Planning Application Reference: BR/3/22/DOC

Proposal: Approval of details reserved by condition imposed under BR/281/18/PL relating to conditions 3-Arboreal meeting, 6-Construction Management Plan, 7-landscape scheme, 8-colour scheme of materials and/or finishes, 9-new screen walls and/or fences, 10-covered and secure cycle parking spaces, 12-dustbin enclosures, 13-electric vehicle charging & 14-decentralised, renewable and low carbon energy supply systems.

Location: 99 Victoria Drive Bognor Regis PO21 2DZ

CONSTRUCTION MANAGEMENT SITE PLAN

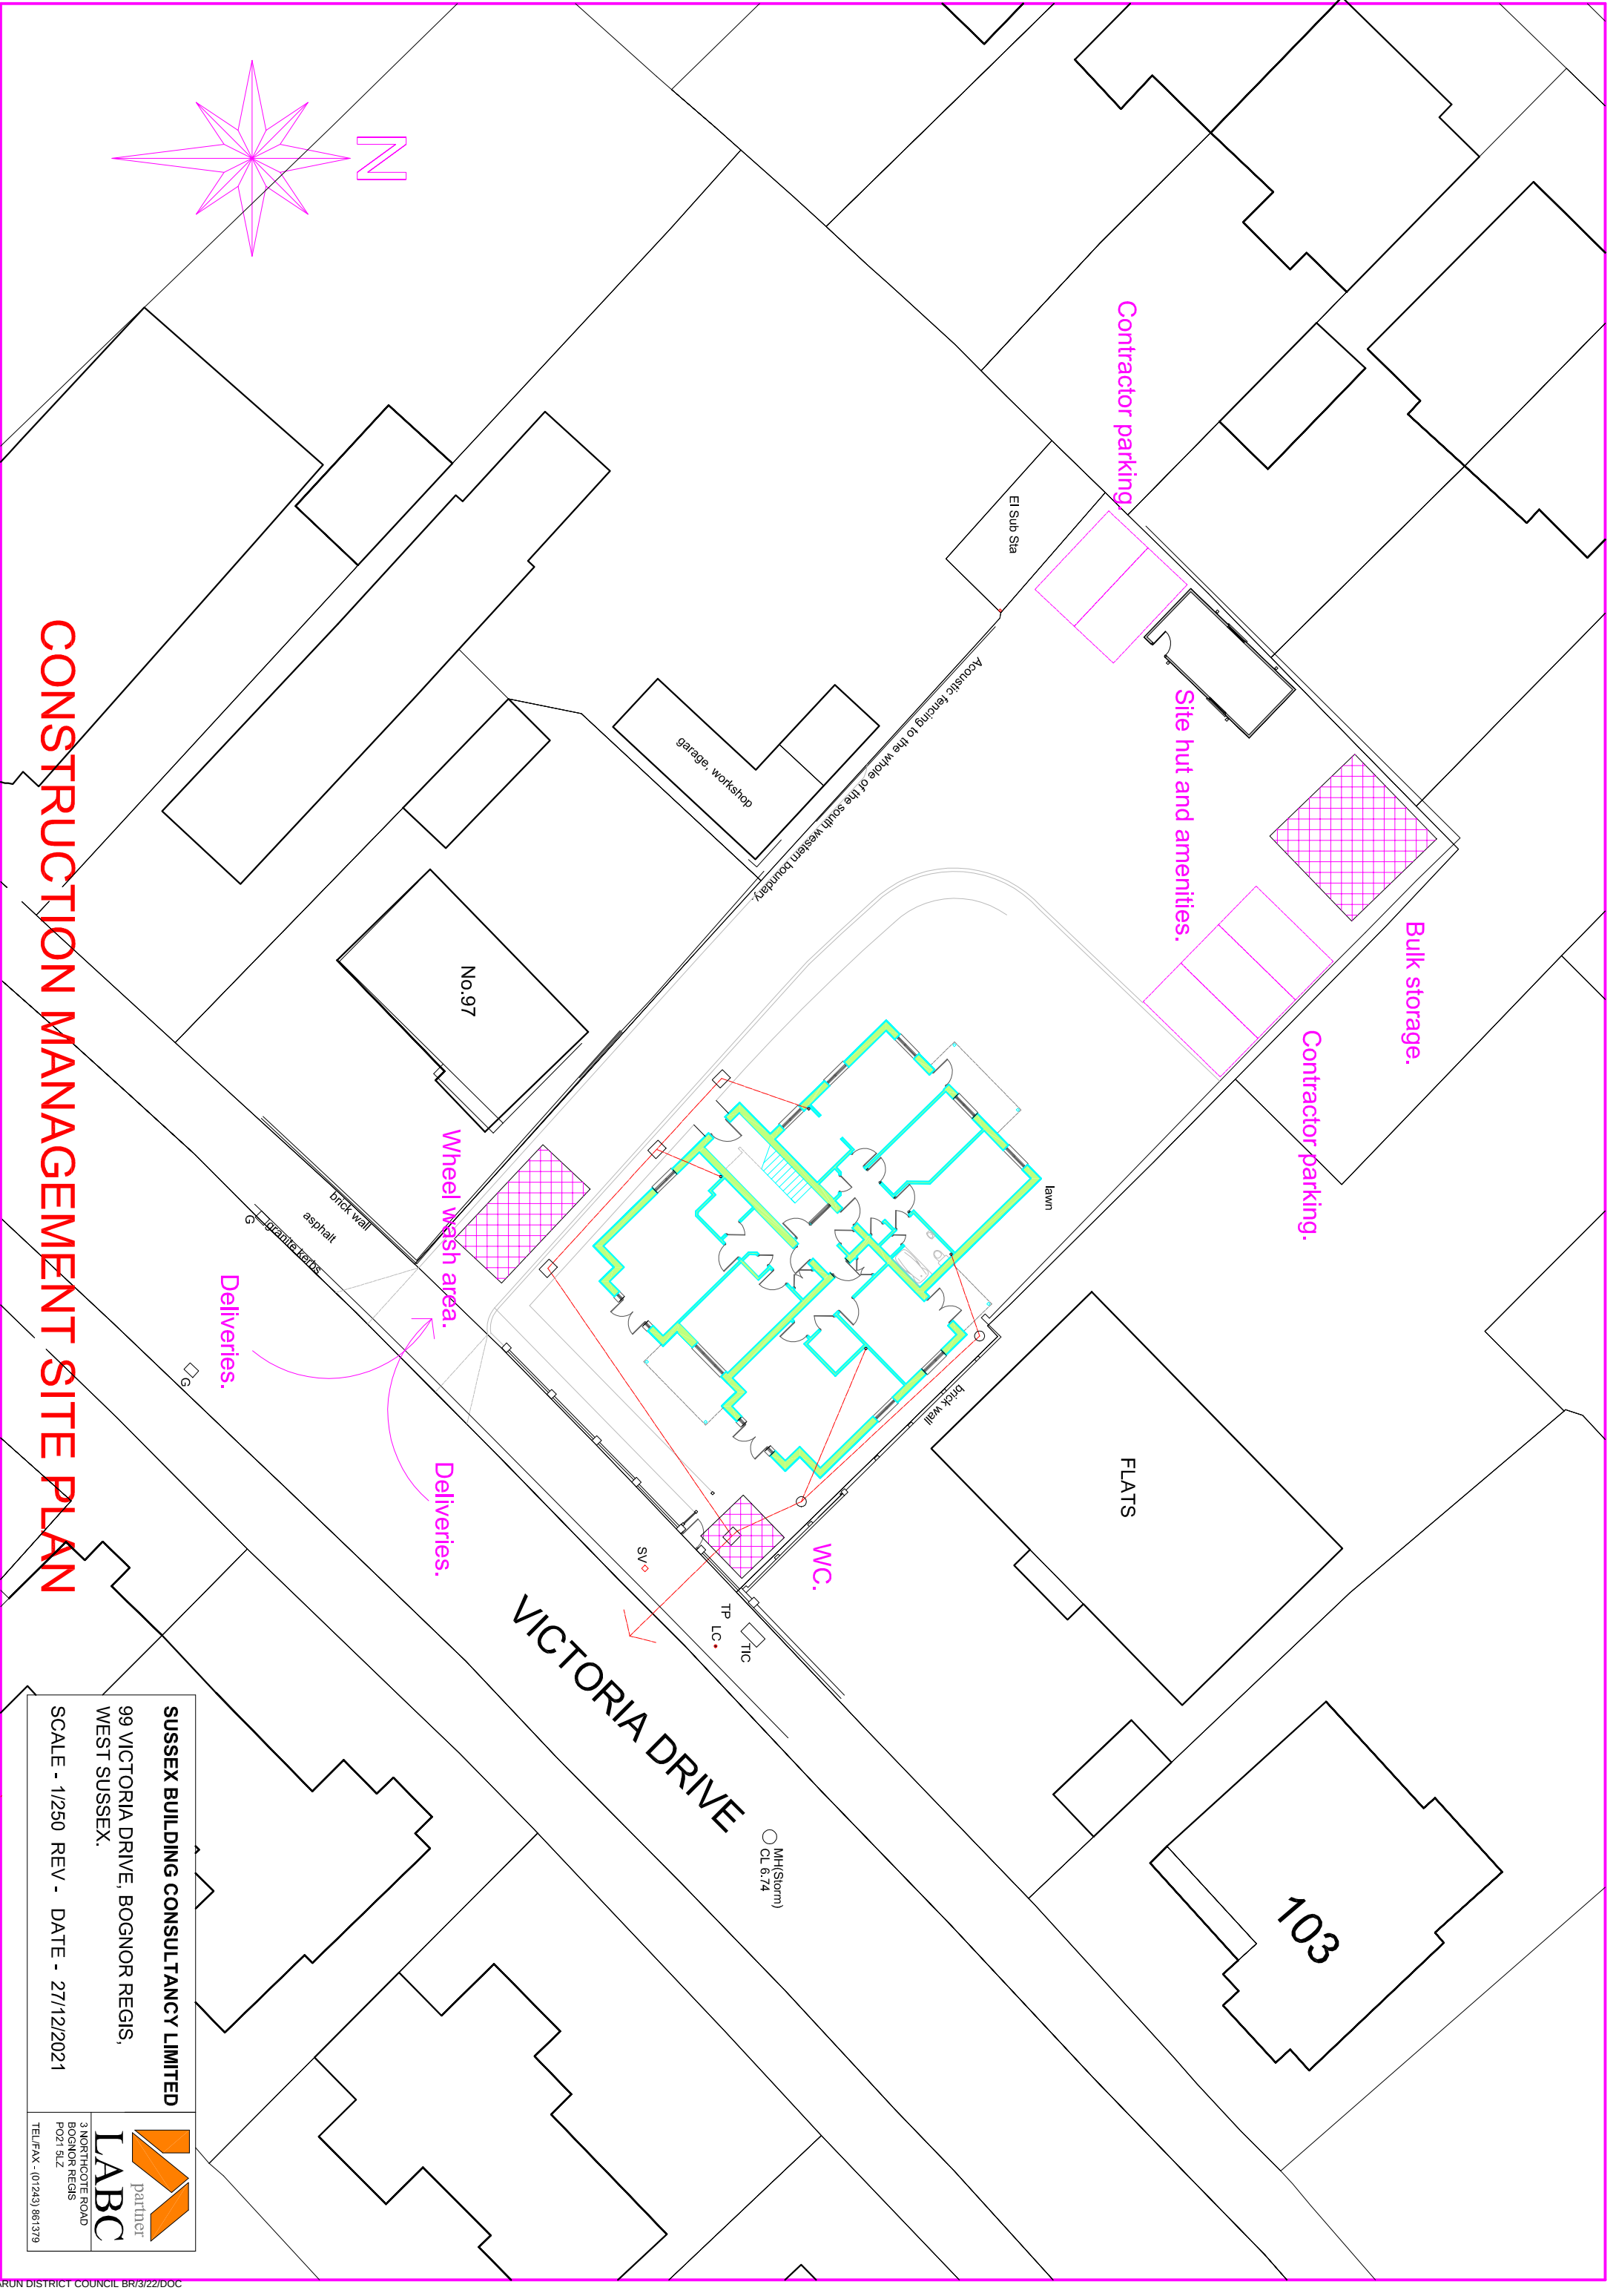
Having reviewed the document entitled 'Construction Management Plan' (no date) [produced by Sussex Building Consultancy Limited], I find the report to be reliable and to meet the requirements of the condition. I therefore recommend the condition can be discharged.

PROPOSED SITE/LANDSCAPE PLAN

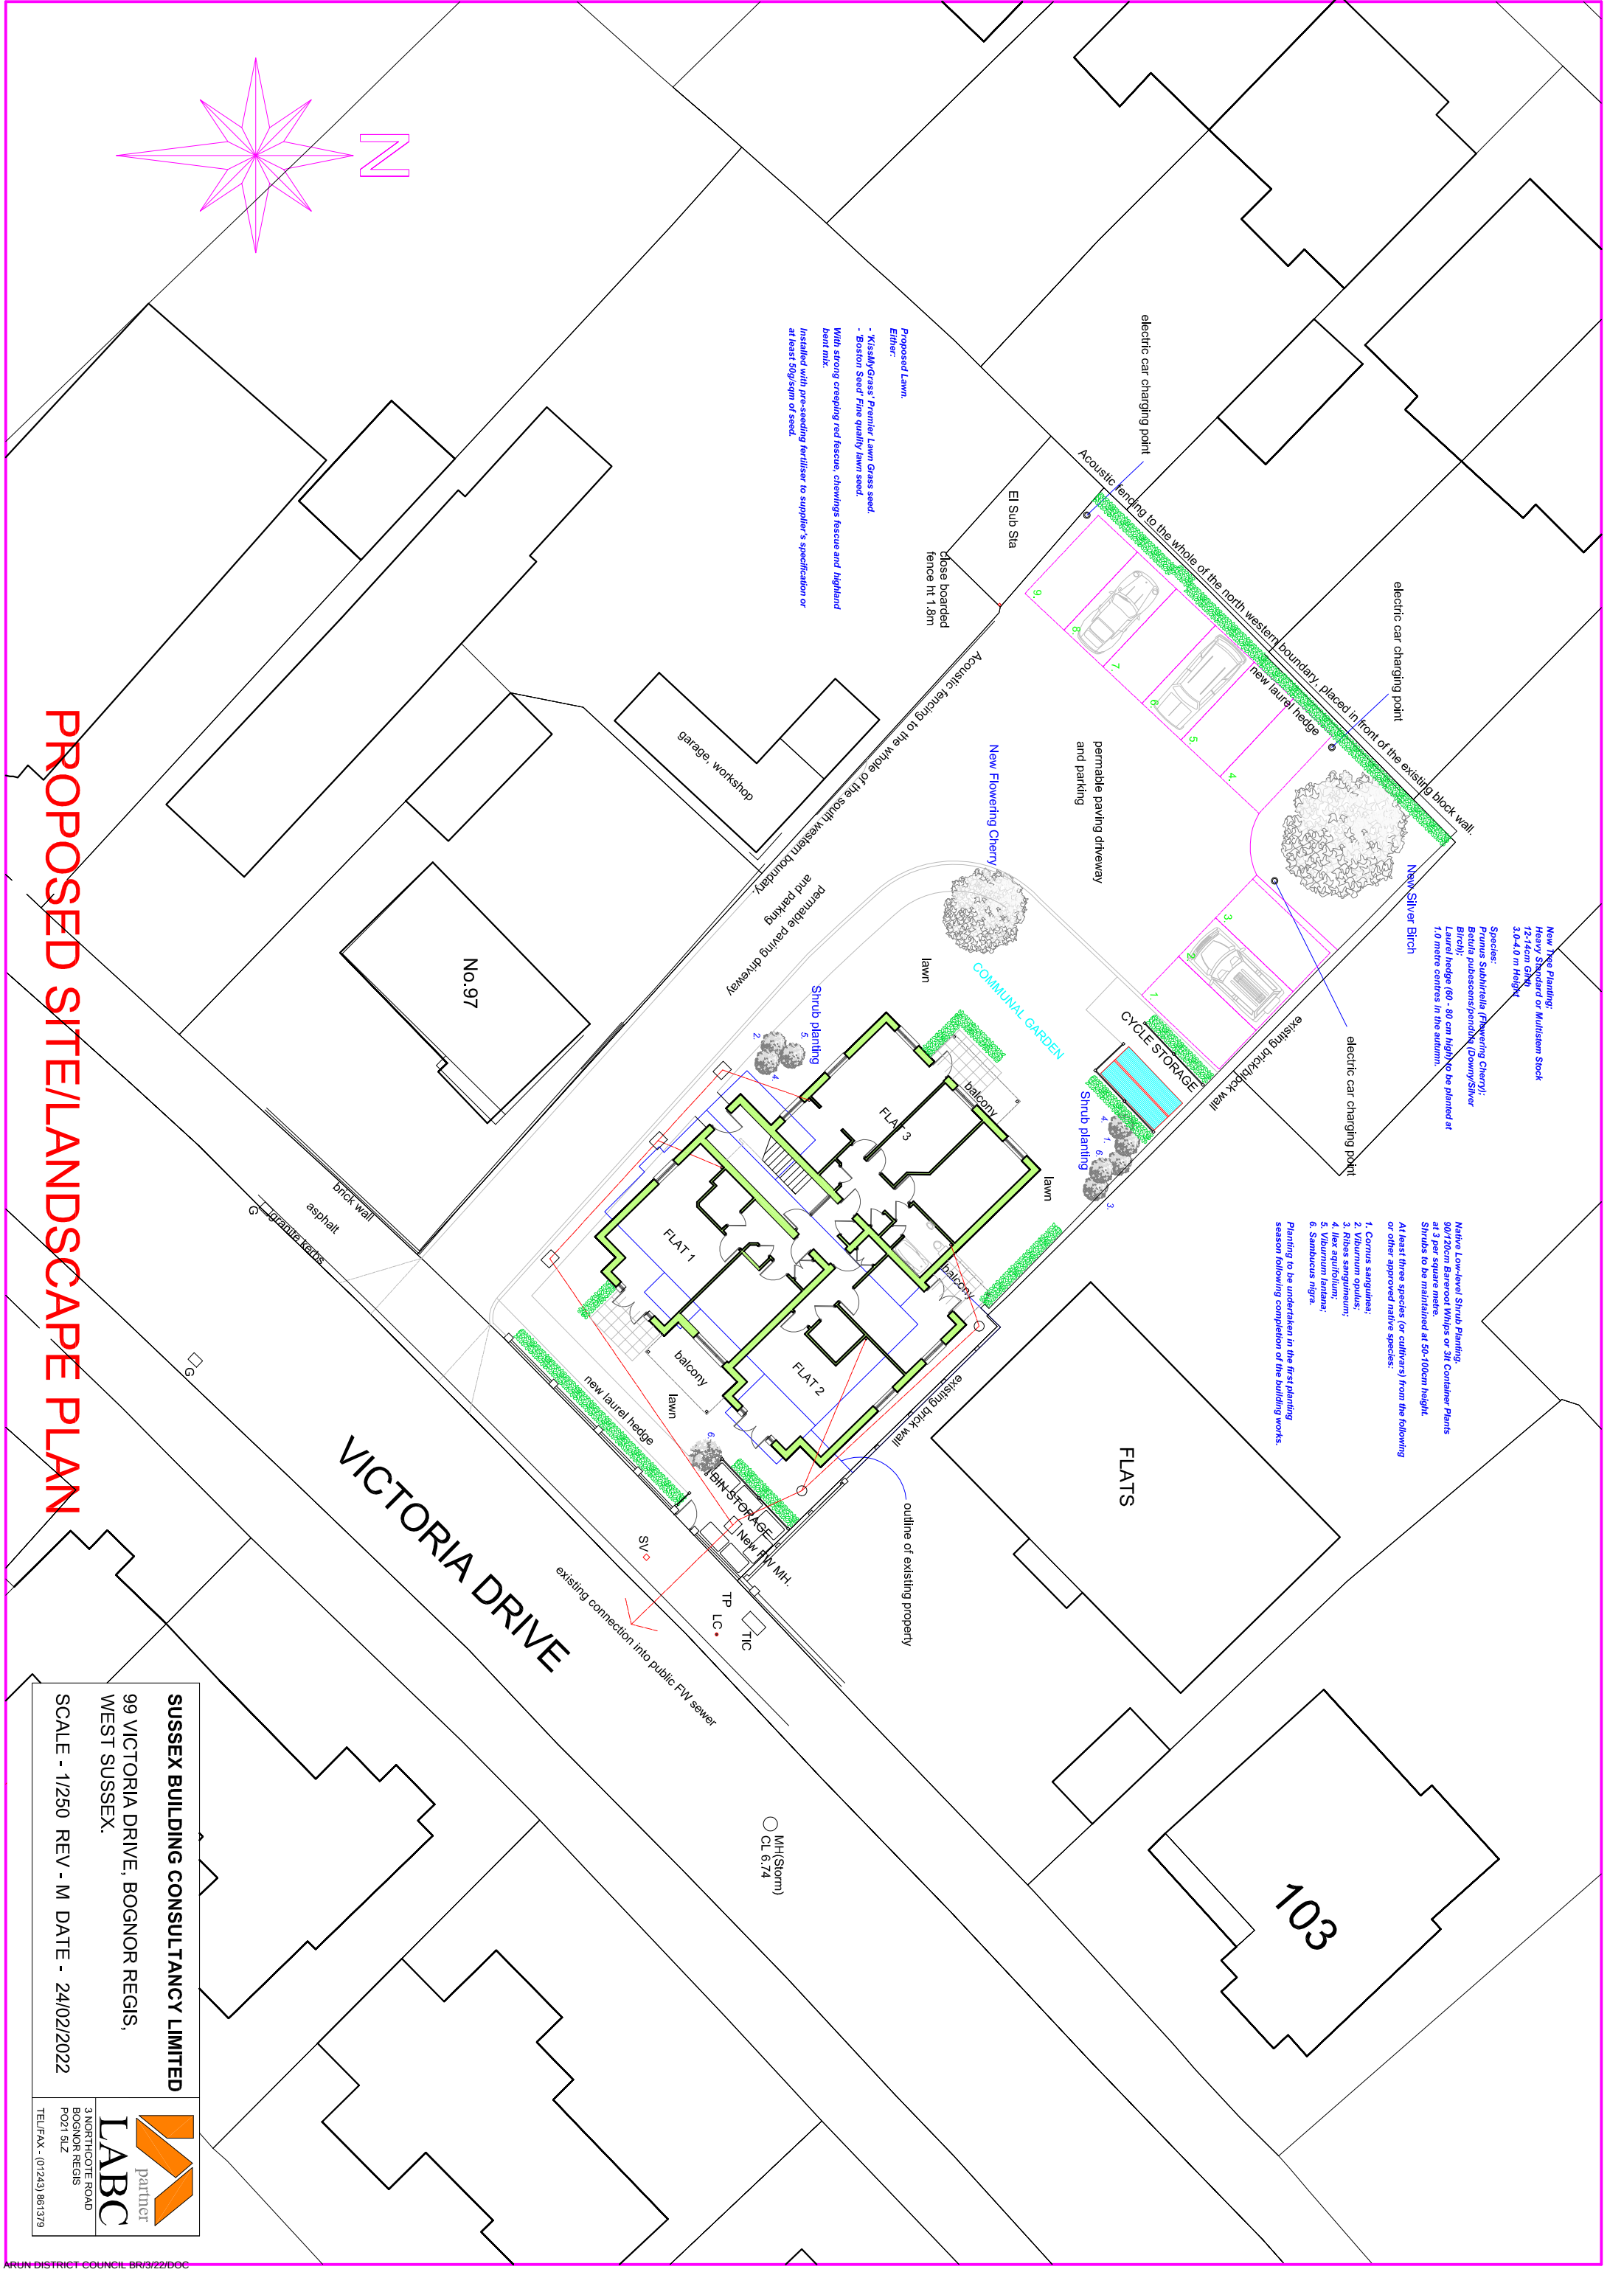
Having reviewed the plan entitled 'Proposed site/landscape plan' (dated 27.12.2021) [produced by Sussex Building Consultancy Limited] I note that the applicant proposes to provide 1 electric vehicle charging point for the 3 flats. Building Regulations approved document 'S' instructs that for new residential buildings with associated parking, there must be an electric vehicle charging point provided for each residential unit within the building – where the number of associated parking spaces is equal to, or greater than, the number of residential dwellings.

Therefore, I request the applicant be required to provide a further two electric vehicle charging points so that the condition may be discharged.

As requested by Craig Milligan, I attach a copy of a revised 'Proposed Landscape Plan' showing the two additional electric car charging points that he asked for to allow for the relevant condition to be discharged.
